KIRKLEES METROPOLITAN COUNCIL INVESTMENT & REGENERATION SERVICE

DELEGATED DECISION TO DETERMINE PLANNING APPLICATIONS

Reference No:	2025/62/93134/W
Site Address:	adj, 30, John William Street, Huddersfield, HD1 1BG
Description:	Installation of 1 black digital communications kiosk with defibrillator (within a Conservation Area)
Recommending Officer:	Joanna Rednall

Officer Report 2025/93134 adj, 30, John William Street, Huddersfield, HD1 1BG

NWP-KIOSK/002B

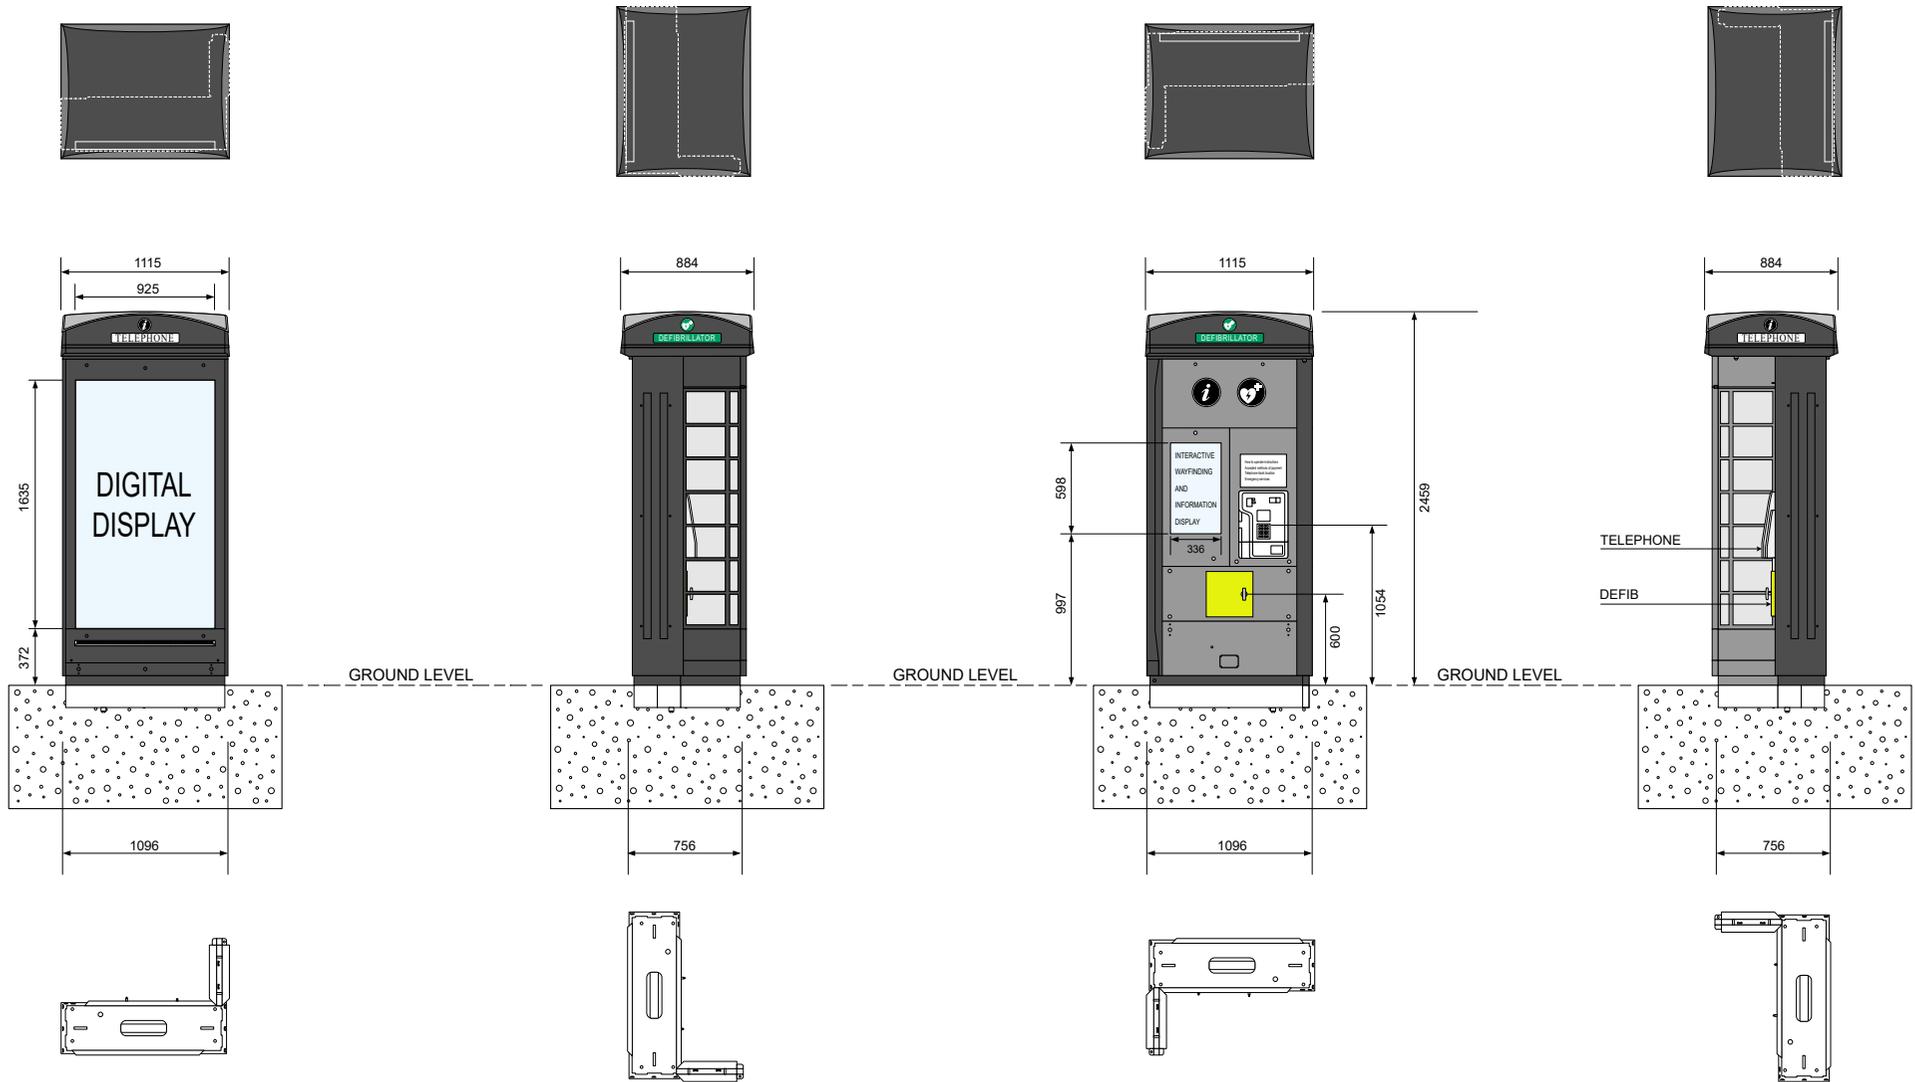
The kiosk is of a telephone box appearance, of a black finish with windows to either side, and one elevation comprising a defibrillator and interactive display screen with the other almost wholly taken up by an internally illuminated digital display screen.

- 2.4m in height
- 0.8m in depth
- 1.1m in width.

that currently benefits from an uncluttered streetscape with minimal street furniture. The introduction of the kiosk, with its illuminated digital screens, would disrupt the clean and historic setting of the row of Grade II Listed Buildings, and in turn the setting of the Conservation Area, thereby diminishing the visual integrity of both the building and the wider Conservation Area.

The proposed digital communications kiosk and defibrillator, due to its scale, prominent location, and illuminated displays, would constitute a visually incongruous and intrusive feature. It would harm the significance of the Huddersfield Town Centre Conservation Area, which includes several nearby listed buildings. The limited public benefits associated with the development do not outweigh the less-than-substantial harm to the heritage assets. Furthermore, the proposal would introduce additional illuminated street furniture, contributing to visual clutter and detracting from the character and appearance of the wider Town Centre. The proposal is therefore contrary to Policies LP17(a), LP24(a), and LP35 of the Kirklees Local Plan, Chapters 12 and 16 of the NPPF and Section 72 of the Planning (Listed Buildings and Conservation Areas) Act 1990.
